**Canal &
River Trust**

Your Ref 2025/91184

Proposal: REVISED AND ADDITIONAL INFORMATION RECEIVED: Erection of two storey industrial unit (Use Class E(g)(iii)), with associated car park, service area and other associated works

Location: Land off Bretton Street, Savile Town, Dewsbury

| TITLE | Drainage Strategy | | | | |

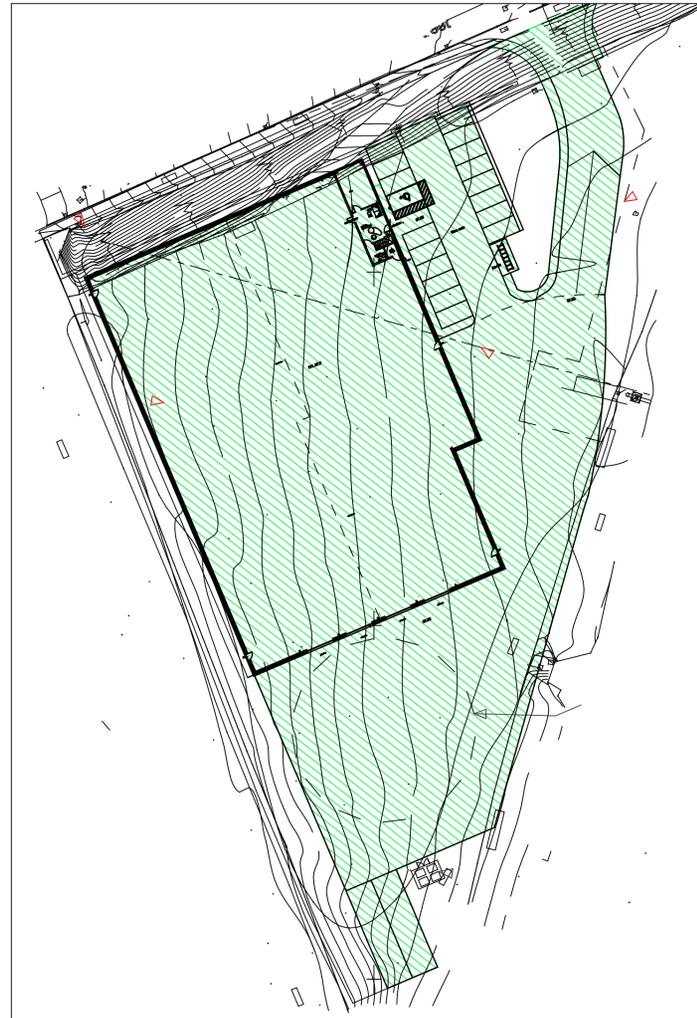
As with the previously submitted details, the submitted drainage strategy shows a proposal to direct both surface and foul water (via package treatment plant) runoff to the canal.

We do request that full details of any Package Treatment Plant should be provided prior to its installation, so that the impact of the foul water connection shown on the canal can be fully assessed. **Details could be reserved through the use of appropriately worded condition(s).**

The Trust's consent as landowner would be required for the runoff shown, even if the proposals seek to utilise any existing outfall. **The Trust has not as yet been contacted by the applicant to confirm that this consent would be forthcoming.** The Trust is not a land drainage authority, and our consent cannot be guaranteed. For more details, our Utilities Section can be contacted by email at utilitiesenquiry@canalrivertrust.org.uk or phone on 07483351479. For more information, the applicant may wish to view the leaflet attached below:

NB. We wish to highlight that correspondence internally with our Utilities Section highlights that a foul water connection to the canal from the package treatment plant may be unlikely to gain consent from the Trust in our position as landowner (notwithstanding any planning consent). As a result, the applicant may find it prudent to amend this detail prior to the scheme being given planning consent to avoid delay in any implementation of the scheme. Should they wish to discuss this with the Trust further, our Utilities Section should be contacted by them via the details listed above.
